13 November 2025

TII25-133452

Re: Strategic Infrastructure Development Application for Construction of a 9 turbine wind energy development (Cooloo Windfarm) and all associated works, Galway

ACP case ref. PAX07.323761

Figure 15-6b Proposed cable route and potential diversion routes

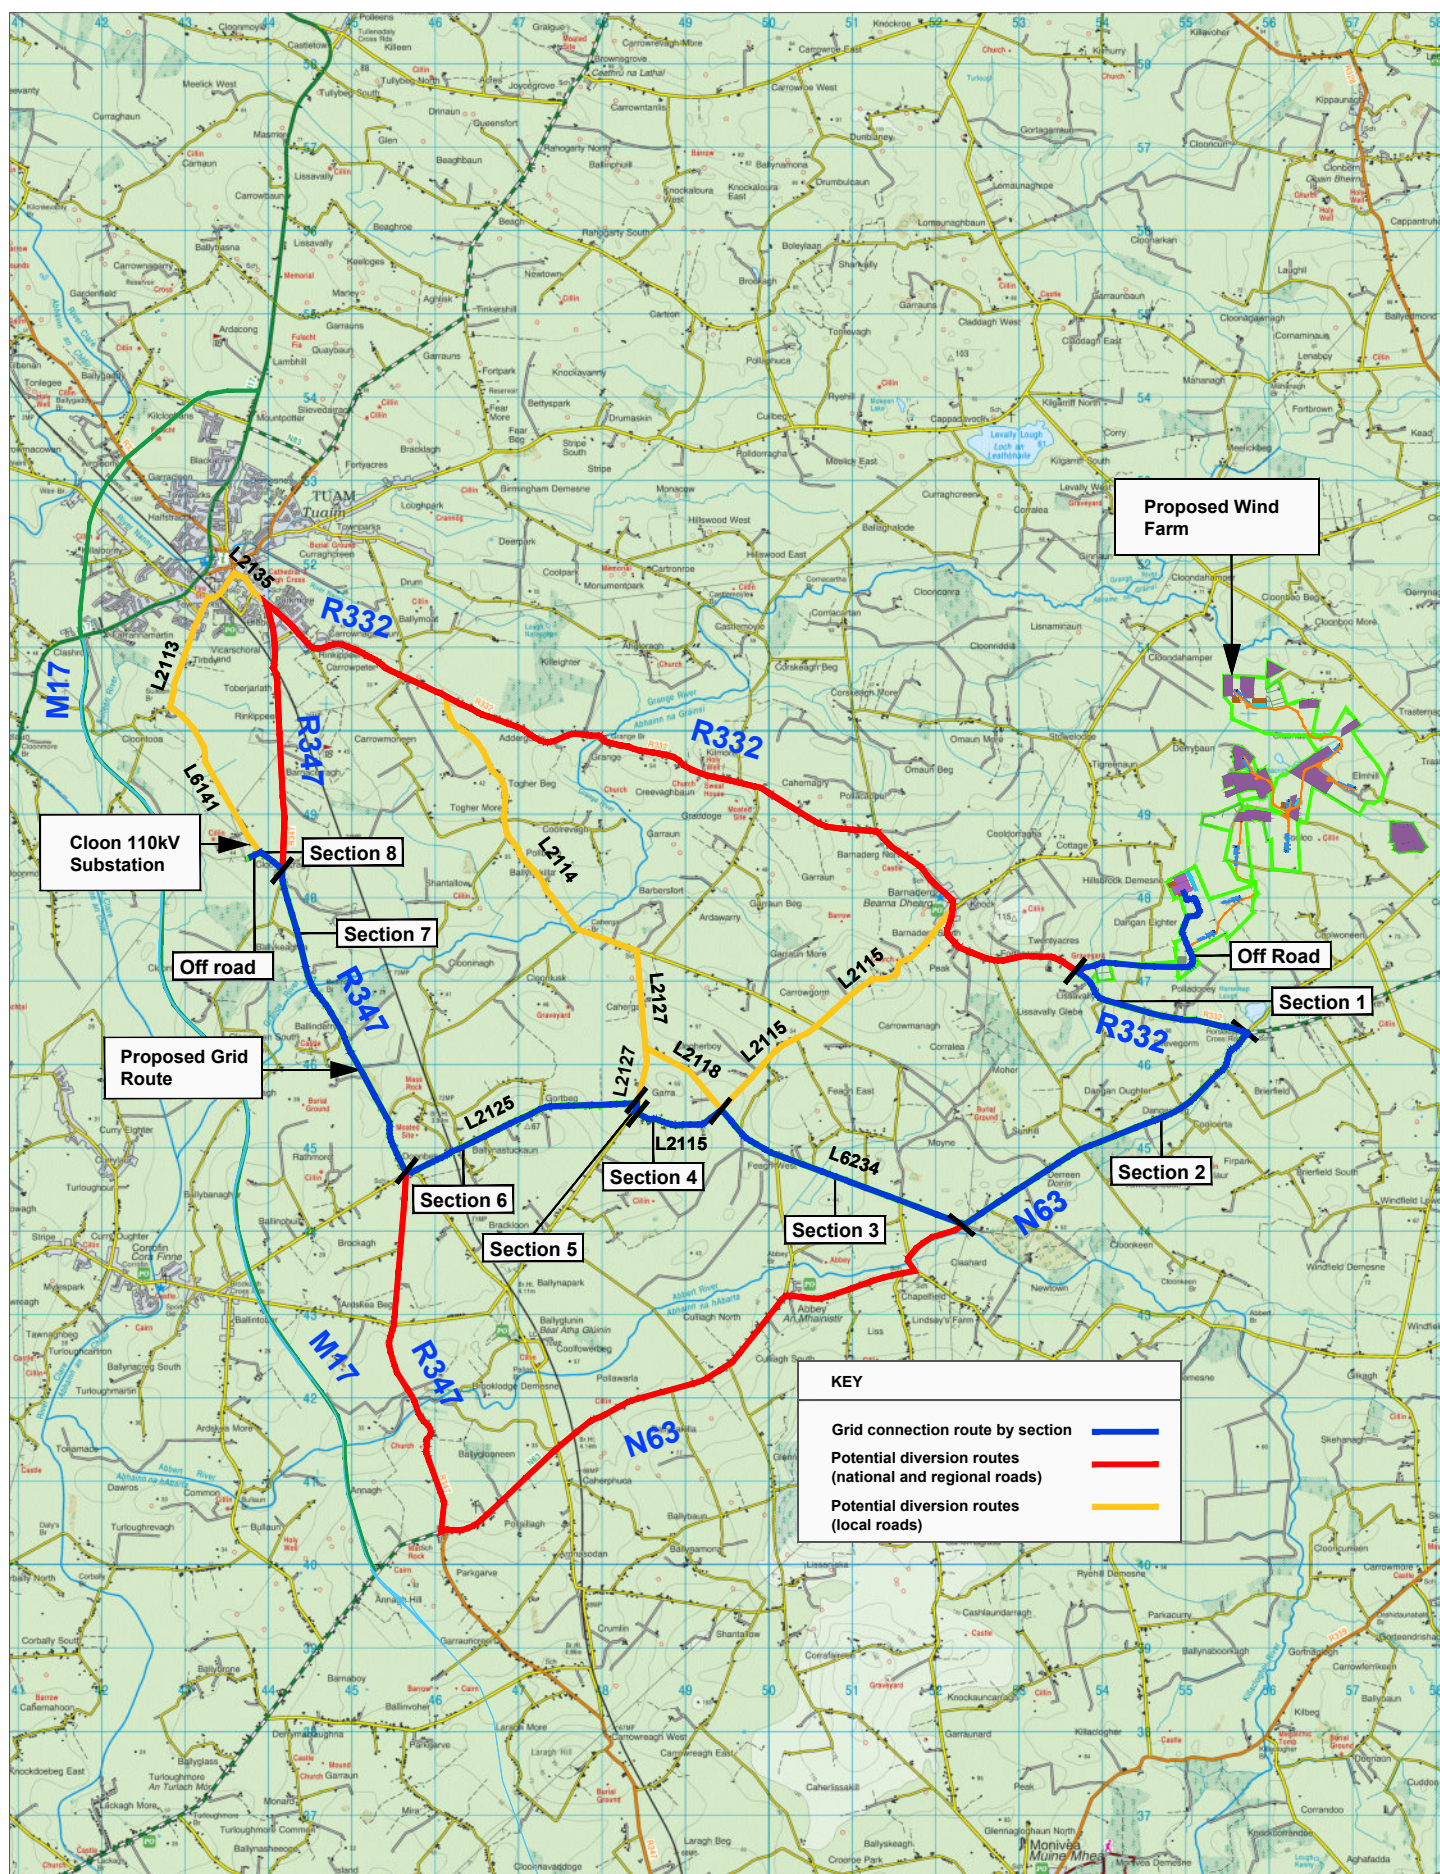
Table 15-26 of EIAR submitted indicates significant impact to the national road concerned identifying closure over 42 construction days and Table 15-27 identifying a diversion route adding 7.1km to associated trips.

- The impacts to the N63, national road, are significant and the EIAR identifies closure of the national road over 42 construction days and Table 15-27 identifies a diversion route adding 7.1km to associated trips.

PROJECT TITLE: Cooloo Wind Farm, Co. Galway			
DRAWING TITLE: Joint bay detail			
PROJECT No.: 190723	DRAWING No.: 190723 - 32	SCALE: 1:25 @ A2	
DRAWN BY: JOB	CHECKED BY: BT	DATE: 23.09.2025	REVISION.: P01

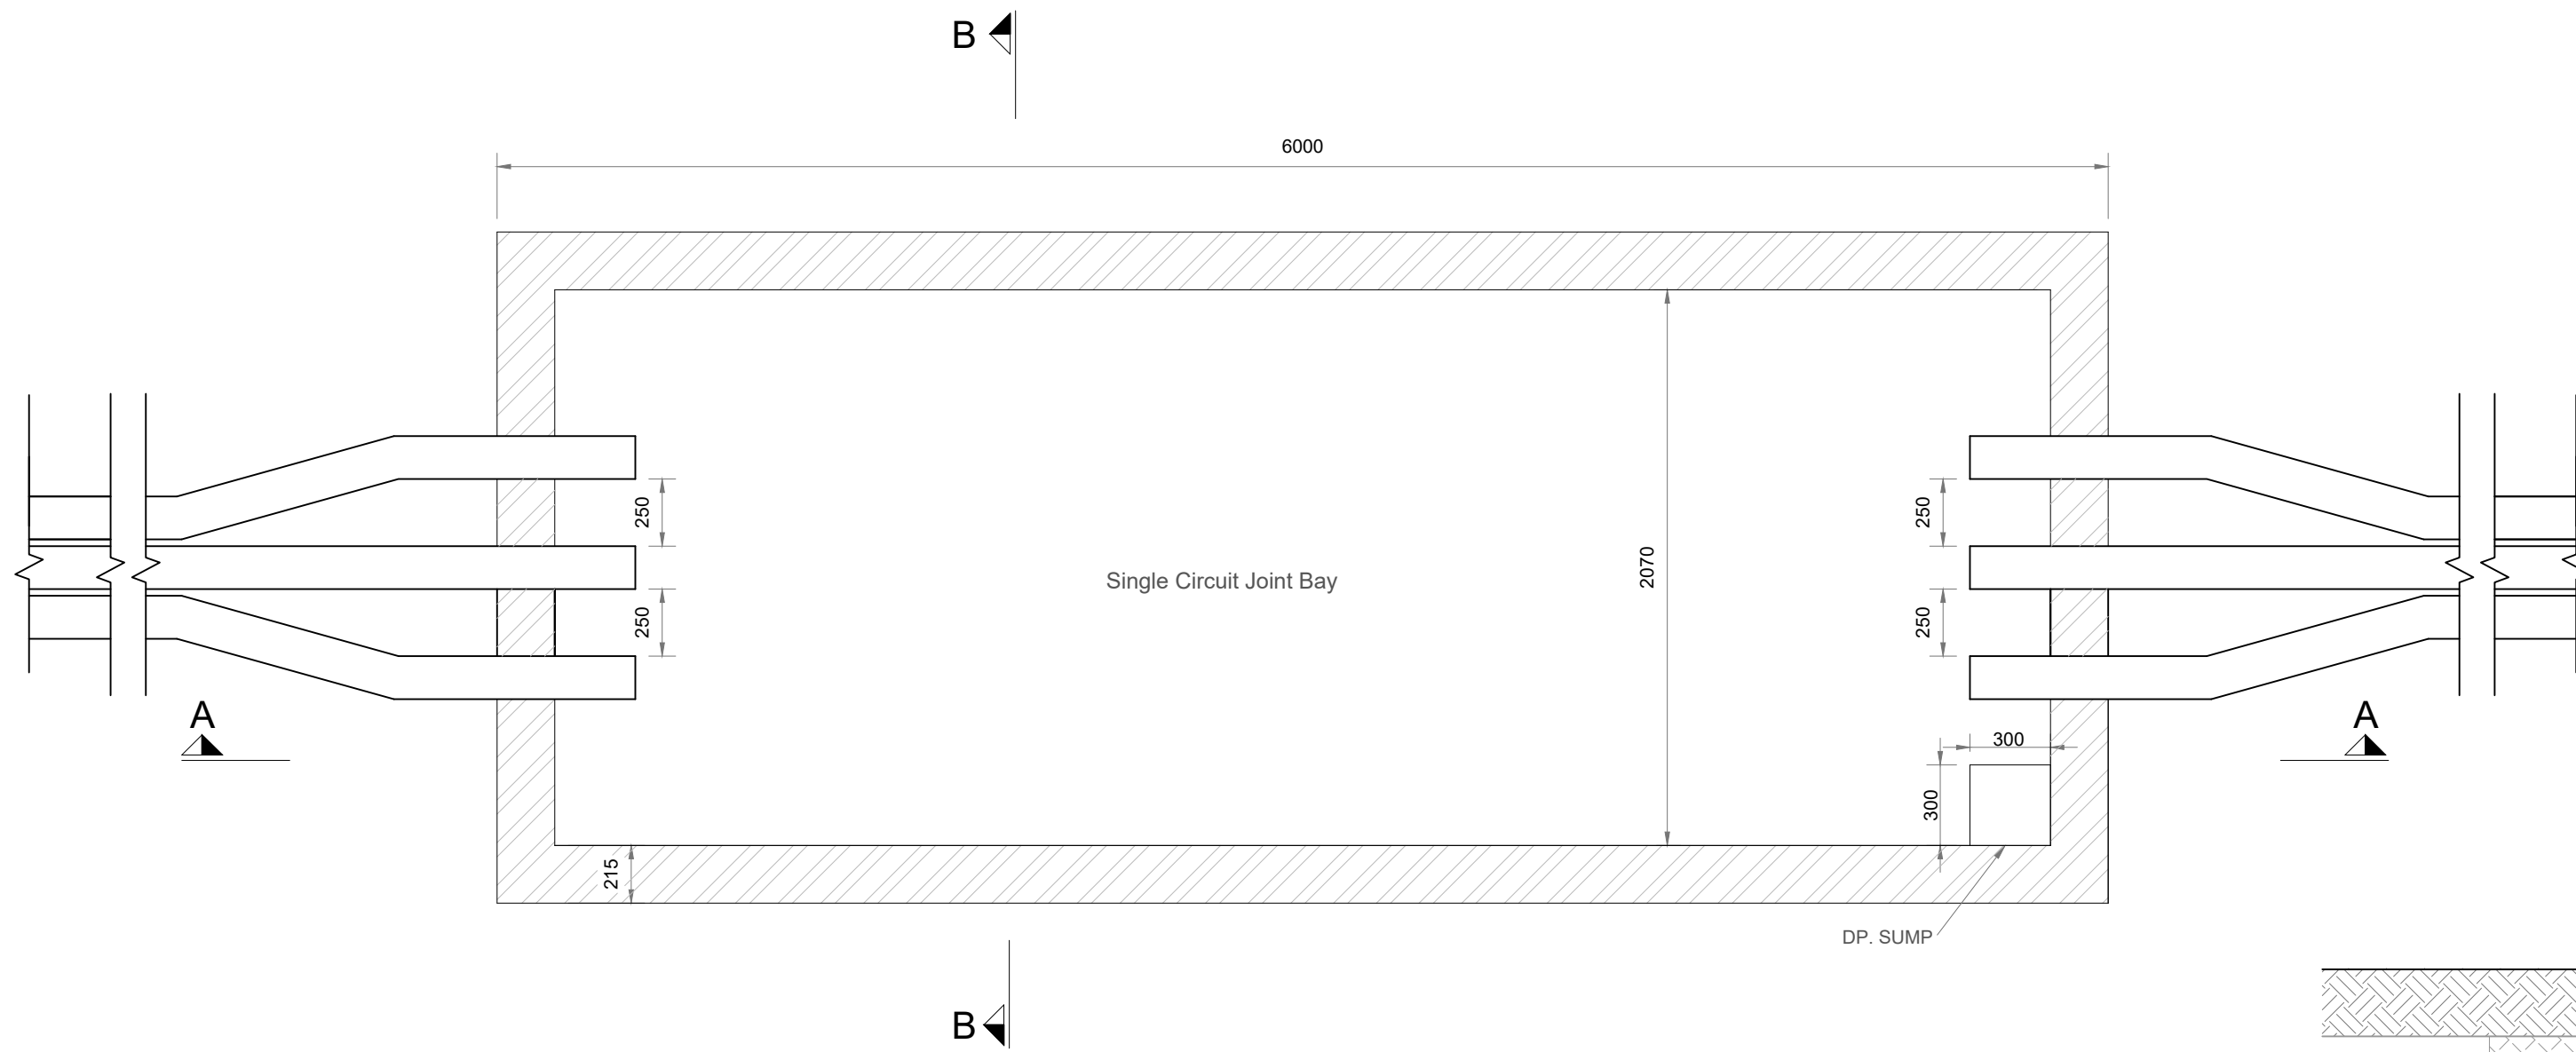
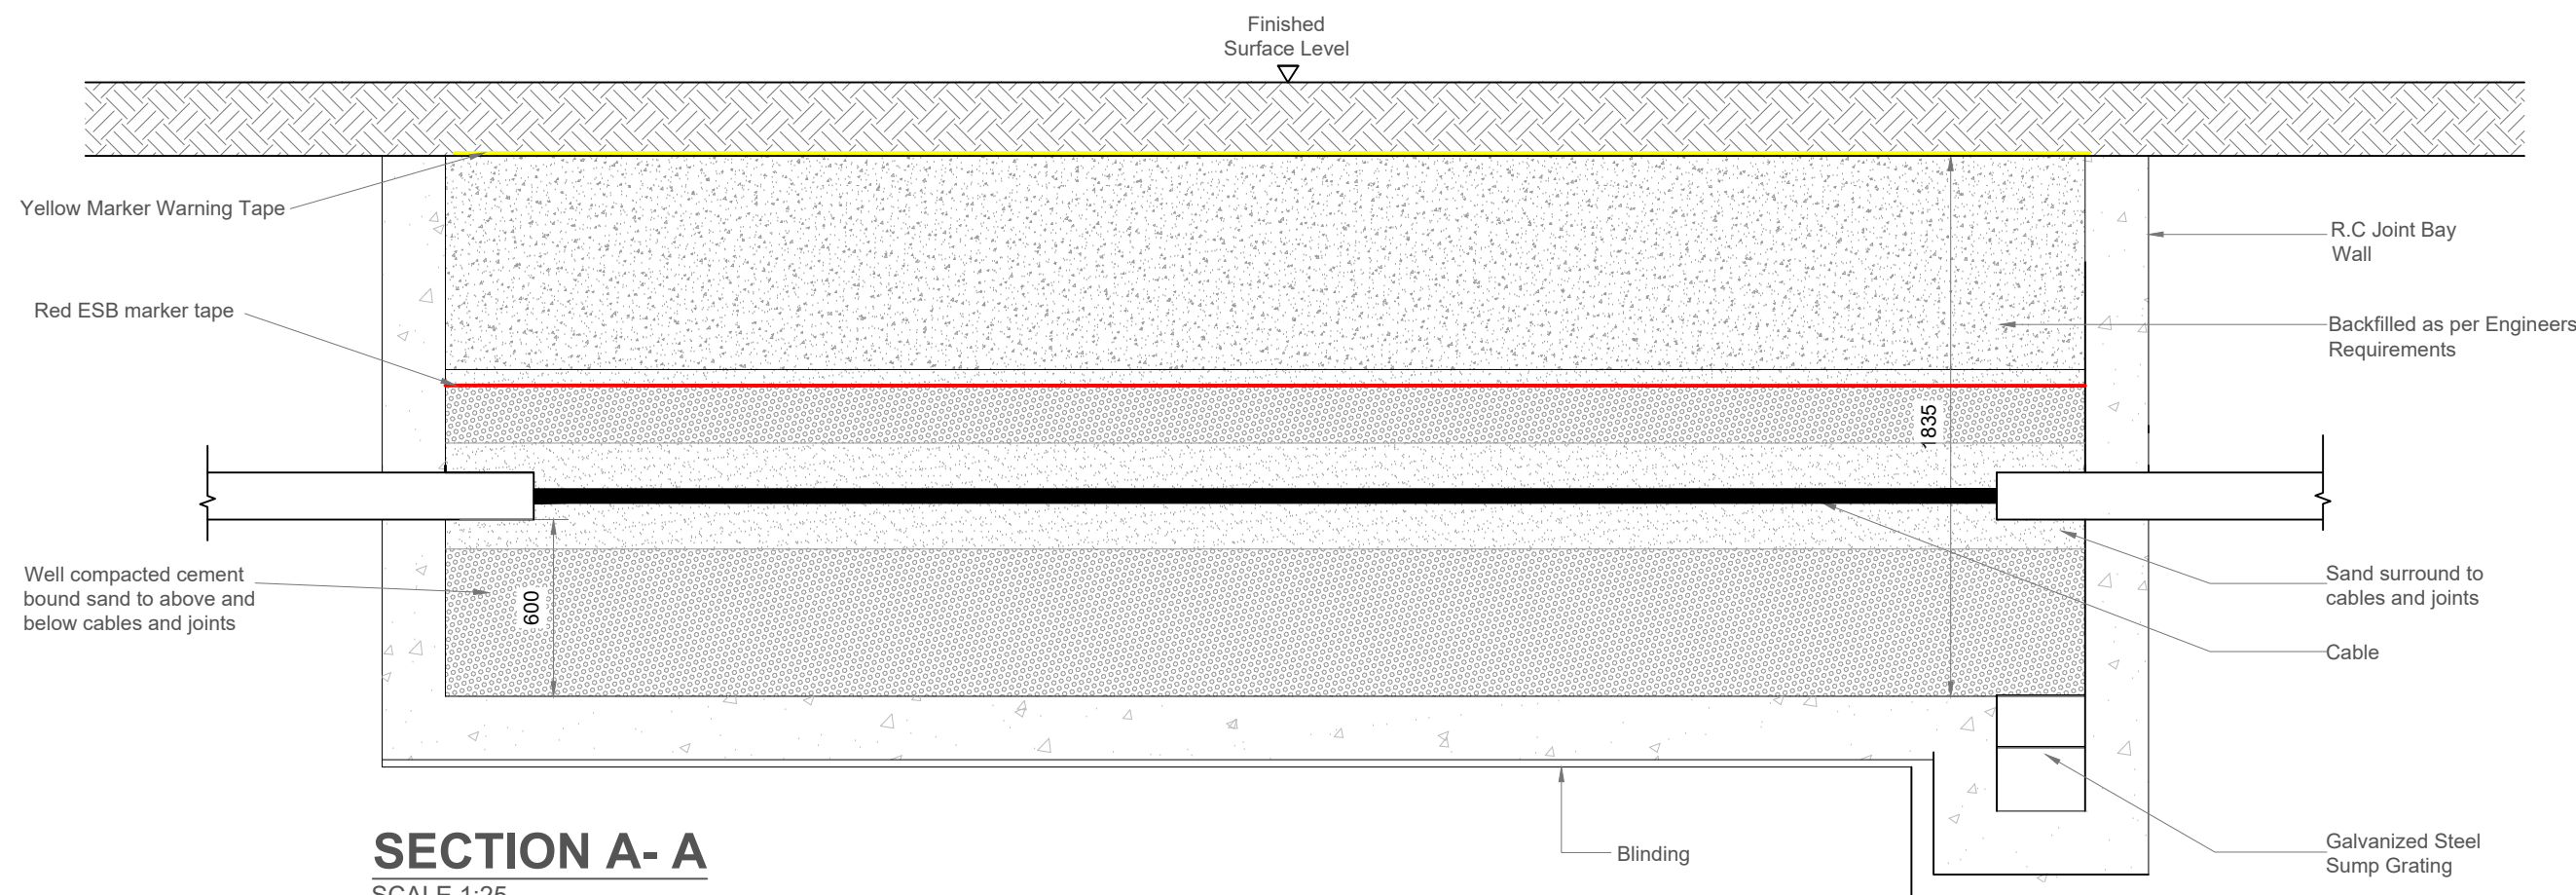
- Drawings included in Appendix 4-4 'Grid Connection Drawings indicate up to 6 proposed joint bays included in the N63 national road reservation. (*Drawings include the text that 'Exact location of cable/joint bay in the road curtilage to be subject to ESB/EirGrid specifications and agreement with Galway County Council'*).
